Fwd: 1,2,3 School Approach Minutes Secured by Design 63421/APP/2015/1457

Please find below, an email correspondence as regards the status to the Secured by Design Certification to 1,2,3 School Approach Fredora Avenue. [63421/APP/2015/1457](#)

SBD Meeting 1

The meeting took place at 1:00pm on 1st May 2015 concerning 1,2,3 School Approach.

Drawing Title
**PROPOSED PLAN, ELEVATIONS &
SECTION**

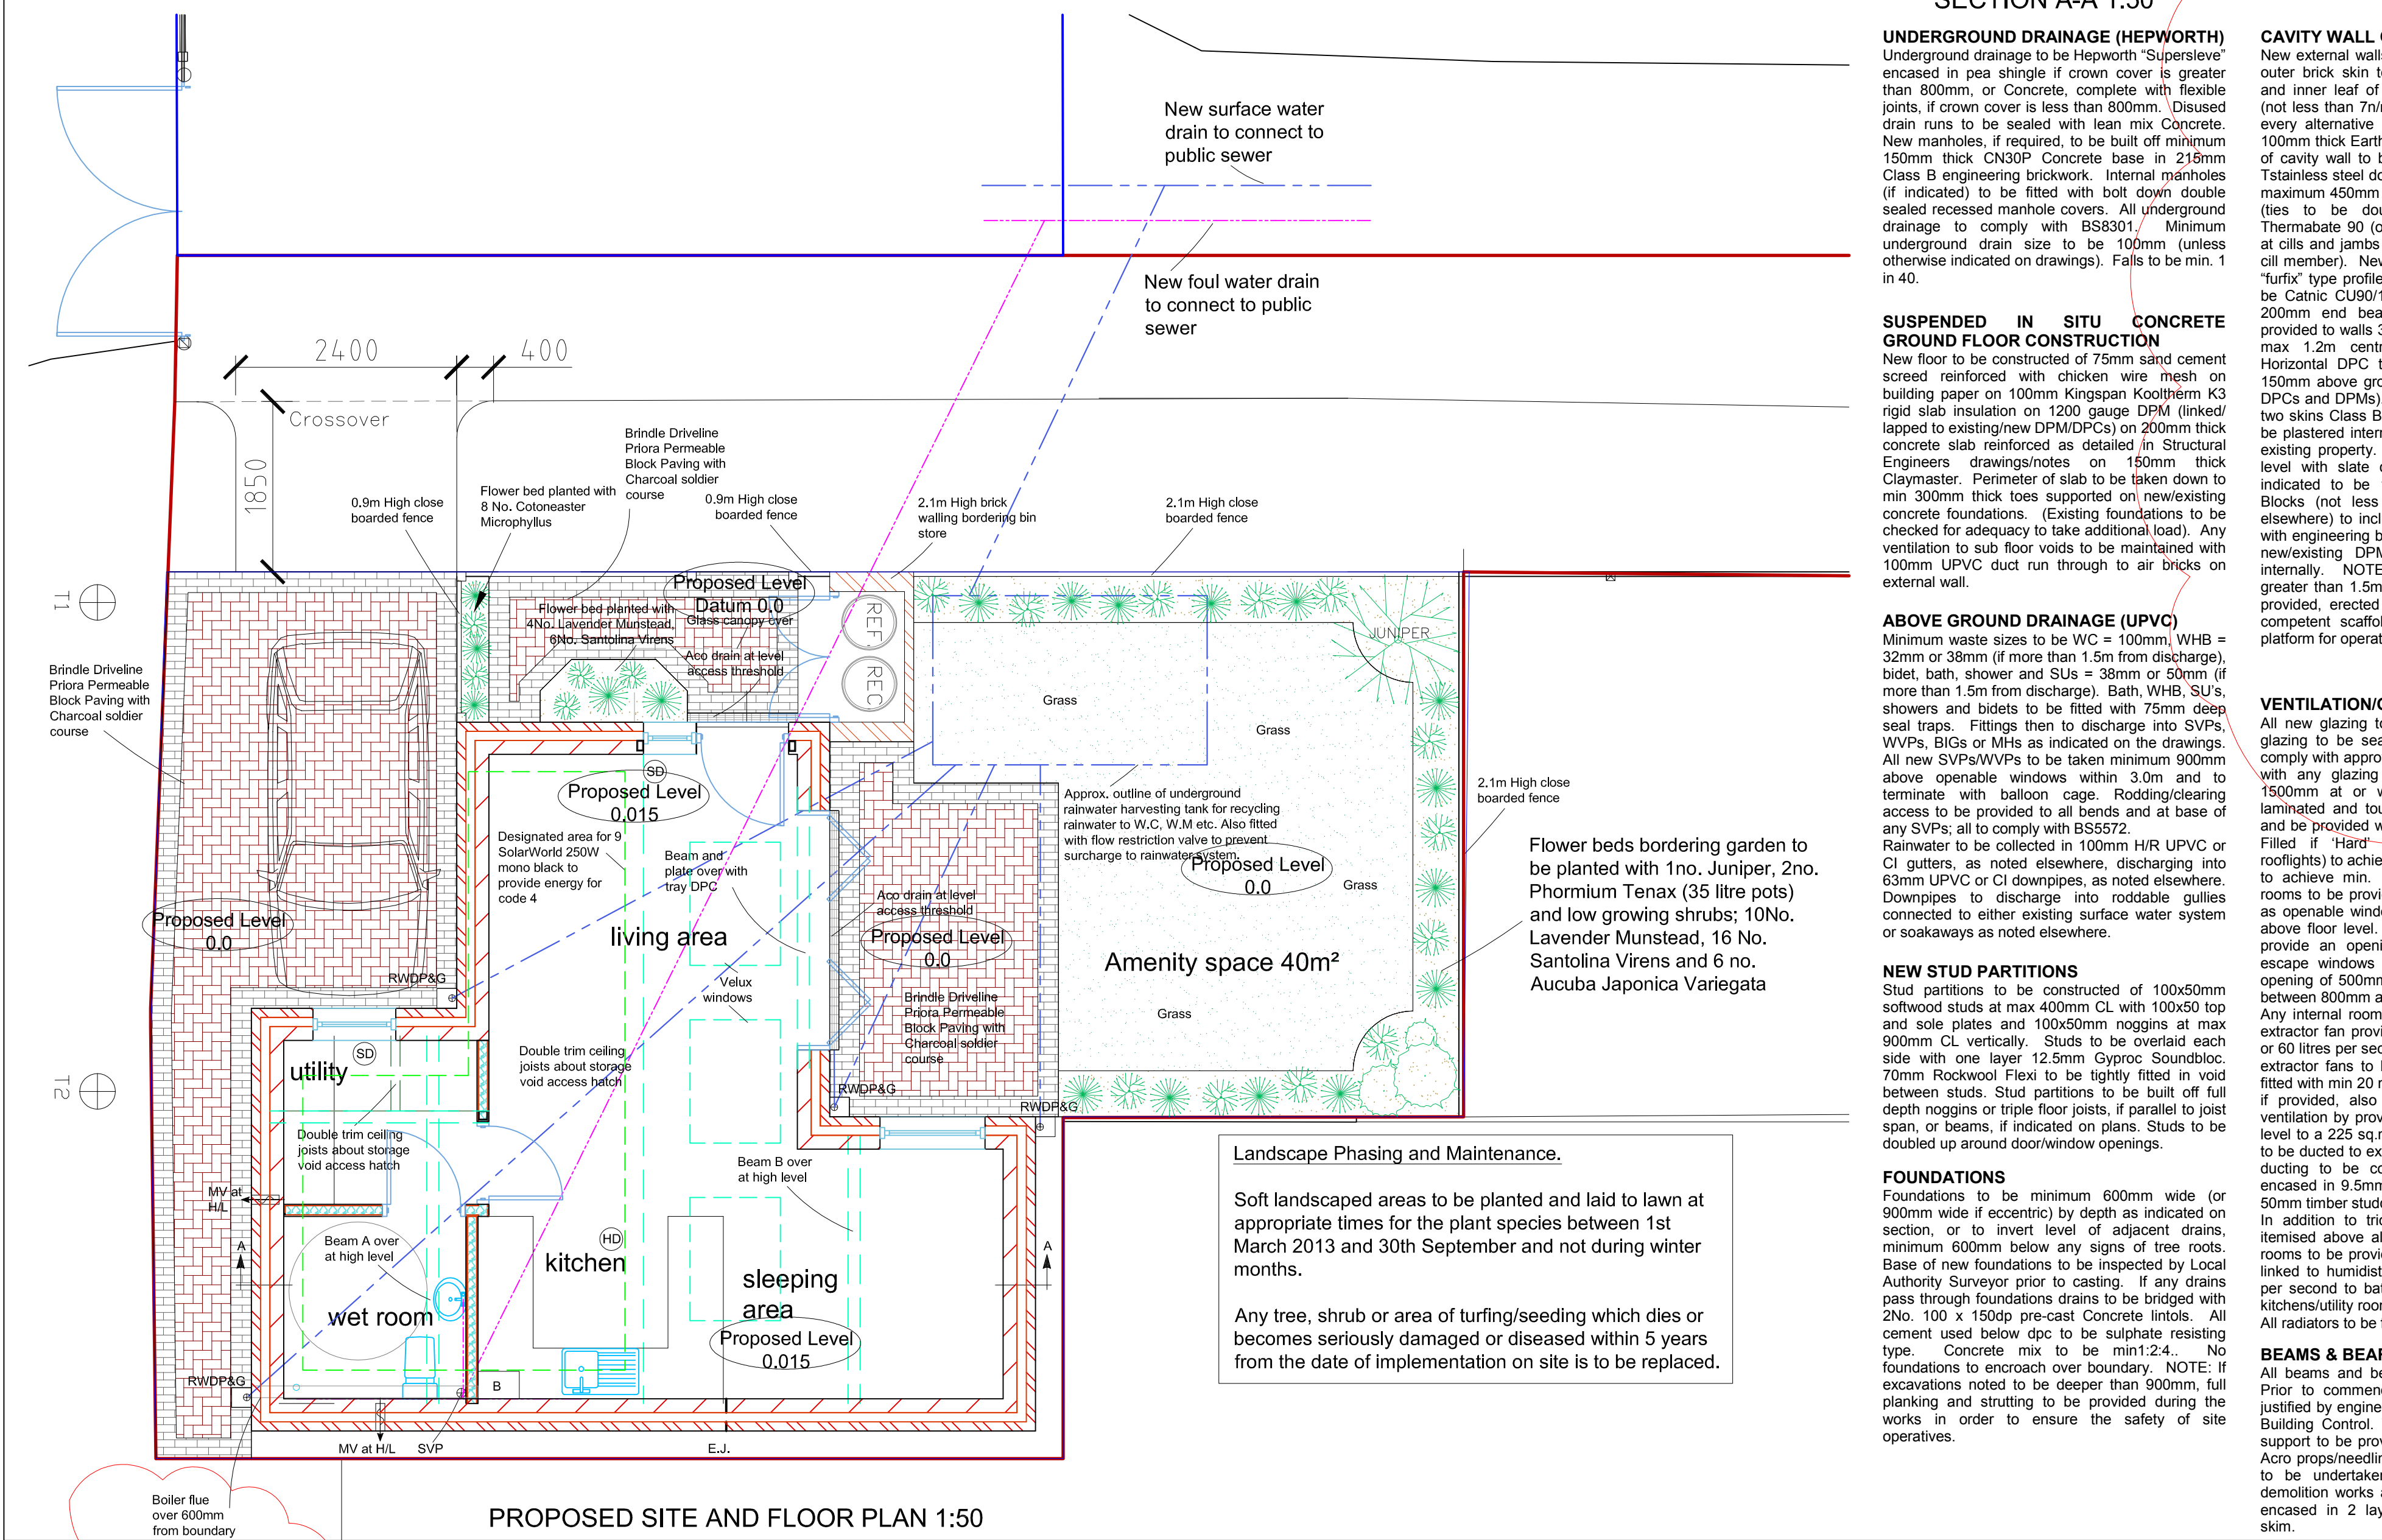
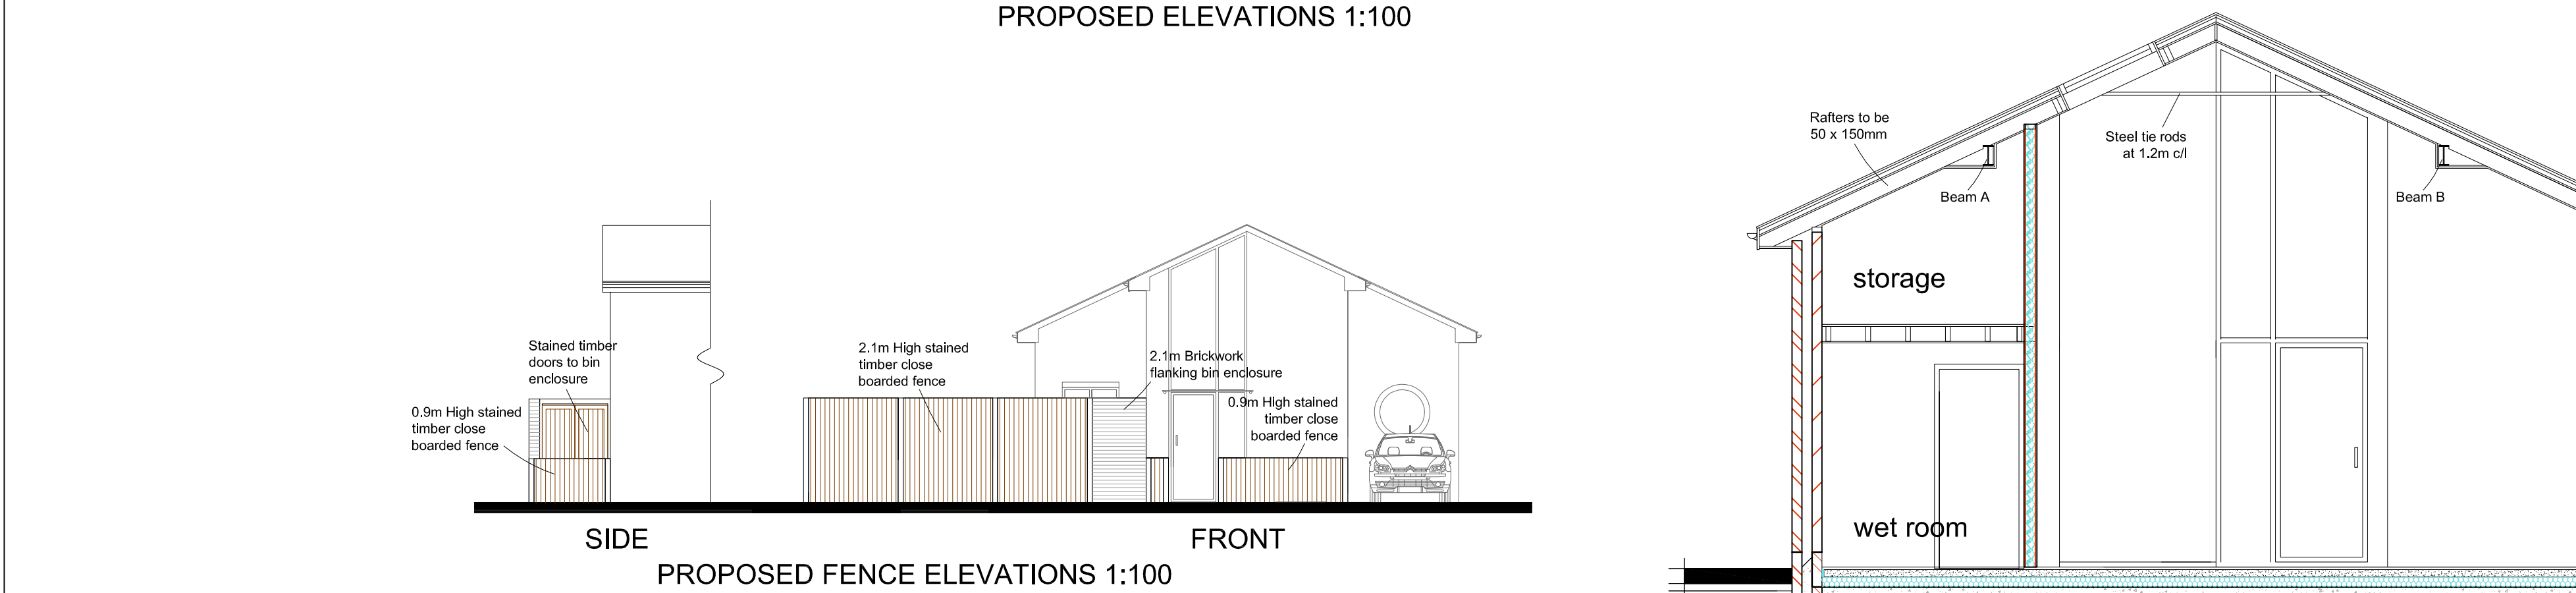
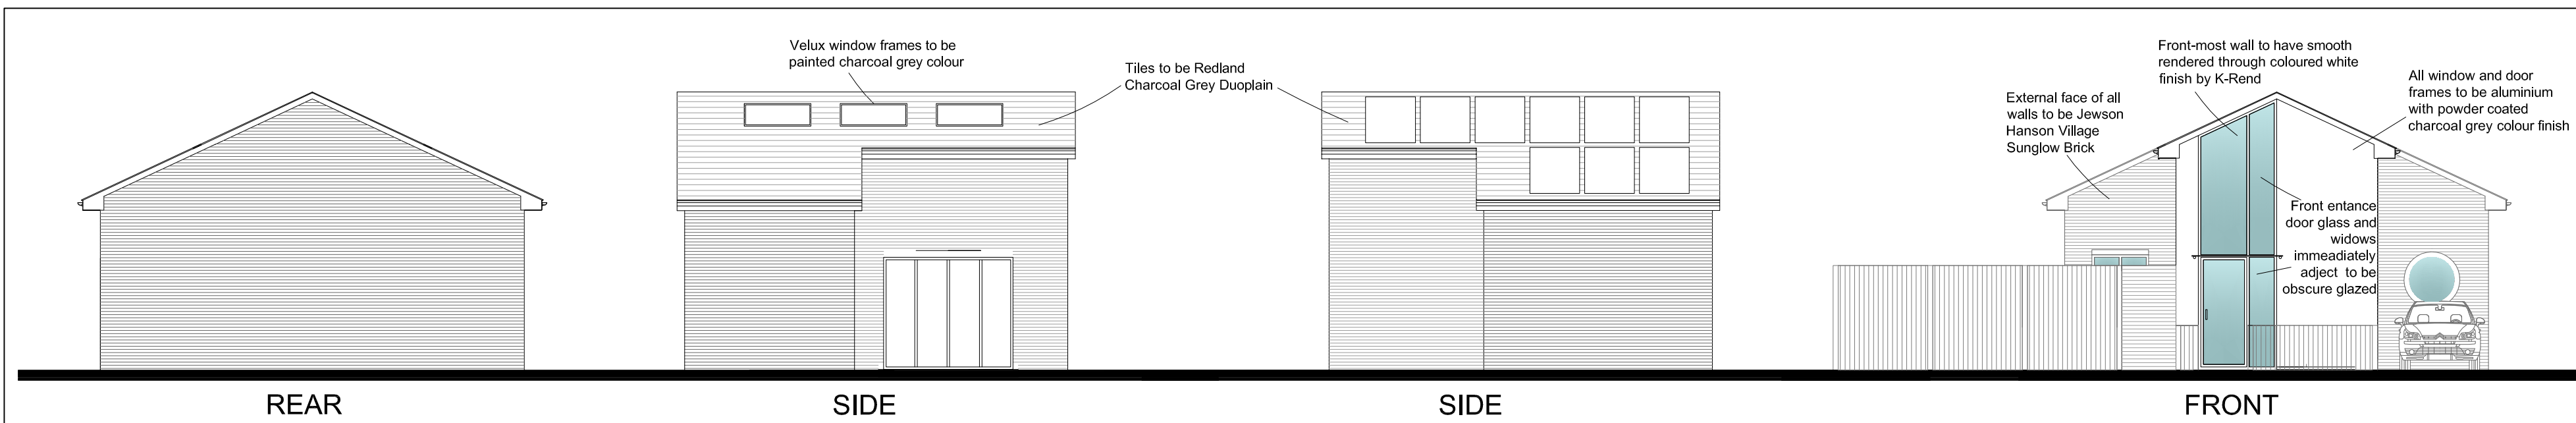
2. The SBD Officer stated concerns for the car park allotted to the site as it was adjacent to a public foot path. The architect noted that currently there was no window from the living room overlooking onto the car. The SBD Officer stated the window will be required for the build to be SBD compliant and the architect agreed to add the flank window.

3. The SBD officer infrastructure for CCTV on the flank wall as well and an non switched 13amp fused spur infrastructure for an alarm system should be built into the design should the occupier wish to install these.

4. The SBD noted PEC external lighting (dusk till dawn and compliant with BS5489) need to be attached overlooking the car and patio at the rear amenity area. It was also noted that the external lighting over the rear amenity space can be switch-able should the occupier use the space at dusk/dawn/during the night.

5. The SBD Officer reminded the architect the front door, glass panes, patio will need to be PAS2012(openings) or PAS24(fixed panelled laminated glass) compliant and therefore need to be provided company name, product number and certificate for each element. The SBD Officer advised for such bespoke elements to be ordered at early as possible to ensure that there are no delays to the build.

6. It was noted by the architect a letterbox needs to be added to the design and the SBD Officer advised the letterbox to be placed through the front wall and to be TS009 compliant.

- Glazing security note
- Com 3 Domestic Letterbox specified

- Added flank window (overlooking car)
- Security note containing CAT5e cabling for CCTV infrastructure
- Security note containing unswitched 13amp fused spur for alarm infrastructure
- Added PEC external lighting (over new flank window and over patio wall)
- Added Letterbox (front wall)
- Added smart meter (by flank window)
